From: Jeff Watson
Sent: Thursday, December 19, 2013 8:26 AM
To: Dave Nelson
Cc: 'clerk@cityofkittitas.com'; building@cityofkittitas.com
Subject: BL-13-00031 Clerf

From: building@cityofkittitas.com [mailto:building@cityofkittitas.com]
Sent: Thursday, December 12, 2013 8:23 AM
To: Jeff Watson
Subject: Clerf BLA Clarification

**BOUNDARY LINE ADJUSTMENT SURVEY**

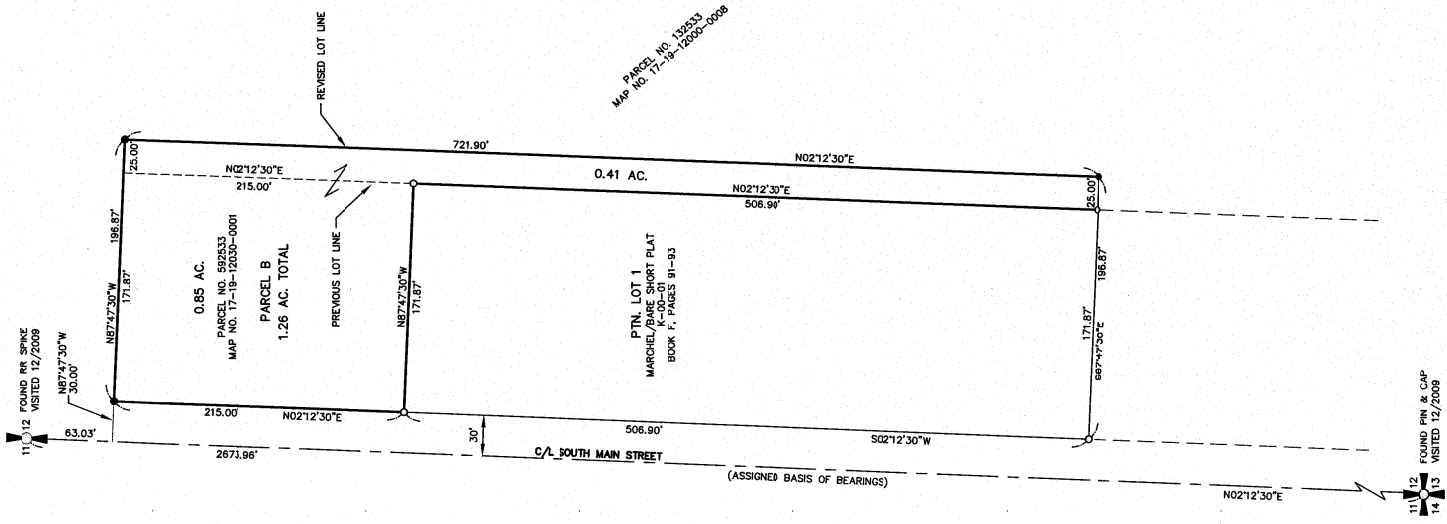
Can you give the City of Kittitas a quick and dirty "Existing and Proposed" site plan for this? Also we are going to need something from Cascade Irrigation indicating they are OK with the changes.

A surveyed map showing the current configuration of the property and the proposed configuration of the property. It is of the utmost importance that we can see which boundary line is being adjusted.

Debbie has forwarded the Clerf BLA to me for review and comment, which I have been working with our planner on. Our planner is requesting some additional information in regards to the Clerf BLA before she is willing to comment. The county map does not seem to match that of the recorded survey that has been submitted. I am assuming that you have access to an updated map on these properties? Please let me know if there is any additional information that we can provide to her to make this more clear. Please feel free to contact me with any questions you may have in regards to this request.

Surveys may be recorded that do not reflect the actual parcel configuration as recognized by the county... I know, weird huh!... so essentially the applicant recorded his proposed configuration assuming it would be approved. Think of it as me recording a document that says the moon is made of cheese; it doesn't make it so, only that I'm dumb enough to officially claim it to be so. Obviously this can be a bit more confusing when it comes to surveys and land use. I don't know why they allow it, but they do. This is why title reports are sooooo essential. For review purposes on this application think of that recorded survey as a "Proposed Configuration" map.
